August 22, 2016

Re: Wastewater Capacity Authorization

Address: 30 Merrill Street

Applicant: Banner Properties, LLC

SEWER / FOUNDATION DRAIN SERVICE CONNECTION
NOT TO SCALE

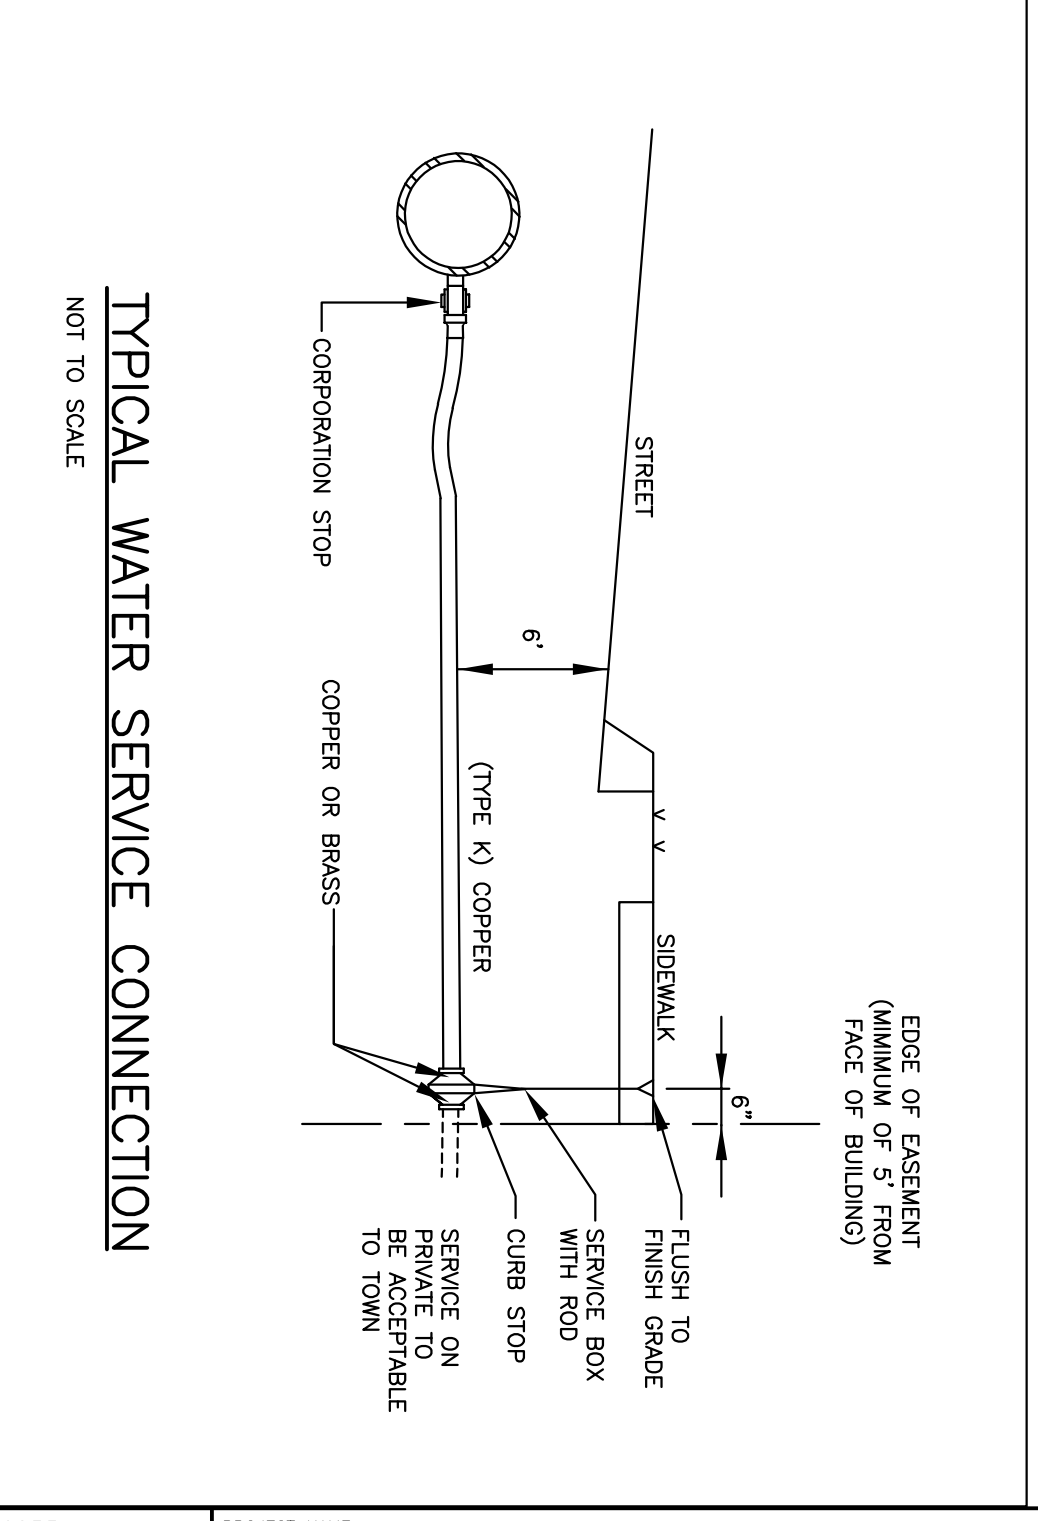
You are reminded that the sewers you are proposing to connect into convey both sanitary and stormwater (Combined Sewer) and therefore a backflow preventer is suggested. Any addition of stormwater flows in this drainage area will have an impact on CSO discharge volumes therefore no roof, sump pump or site drainage may be discharged to the sanitary sewer.

Information available in the City's archives indicate the building is served by an 8" cement pipe installed in 1938 connecting into Merrill Street. I would suggest it be investigated/confirmed for condition.
